Council Reference: DA21/0233 LN 41917  
Your Reference: SSD-10398

## **Tweed Shire Council Submission – Hanson Tweed Sand Plant Expansion - State Significant Development (SSD-10398)**

I refer to the Department's request for Council's advice / comment on the Response to Submissions (RTS) for the Hanson Tweed Sand Plant Expansion (SSD-10398). Council officers have undertaken a review of the proponent's RTS and supporting documentation and provide the following comments for the Department's consideration, noting the proposed changes to the development in terms of: the reconfiguration of the proposed access to the Tweed Valley Way / M1 interchange; amended location of the proposed internal haulage route; sealing the full extent of the internal haulage road; increased buffer widths; removal of lake bunding; and changes to the lake configuration to incorporate the proposed amendments.

APPENDIX 1 - END USE AND FINAL LANDFORM PLAN (ZONE LANDSCAPE ARCHITECTURE 2025)

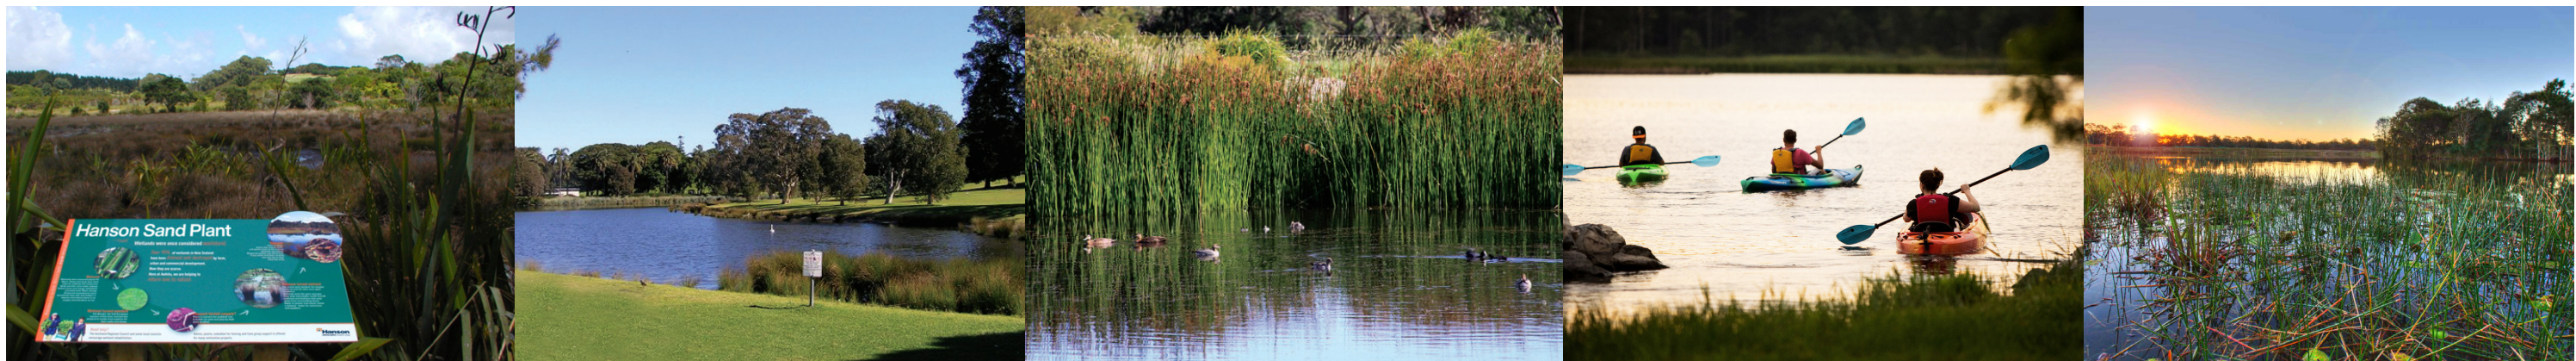
- b. Identify onsite offset areas additional to those Open Space & Riparian Rehabilitation Areas shown on Dwg. No. Z19163-F126 Figure 26 Concept Final Landform Plan and buffer zones identified on Council's indicative buffer plan consistent with current best practice ecological offset ratios; and

- d. Residual impact upon Preferred Koala Habitat mapped outside those Open Space & Riparian Rehabilitation Areas shown on Dwg.

No. Z19163-F126 Figure 26 Concept Final Landform Plan and buffer zones shown on Council's indicative buffer plan should be offset in accordance with the TCCKPOM. Offset receiving sites should be identified and a Koala Offset Management Plan prepared. Offsets are to be additional to any ecological buffer requirements and residual offsetting under the Biodiversity Offsets Scheme.

- All areas identified on Dwg. No. Z19163-F126 Figure 26 Concept Final Landform Plan;
  - Buffer zones and associated red flagged values shown on the indicative buffer plan prepared by Council (Figures 2 and 3) provided in Council's initial submission;
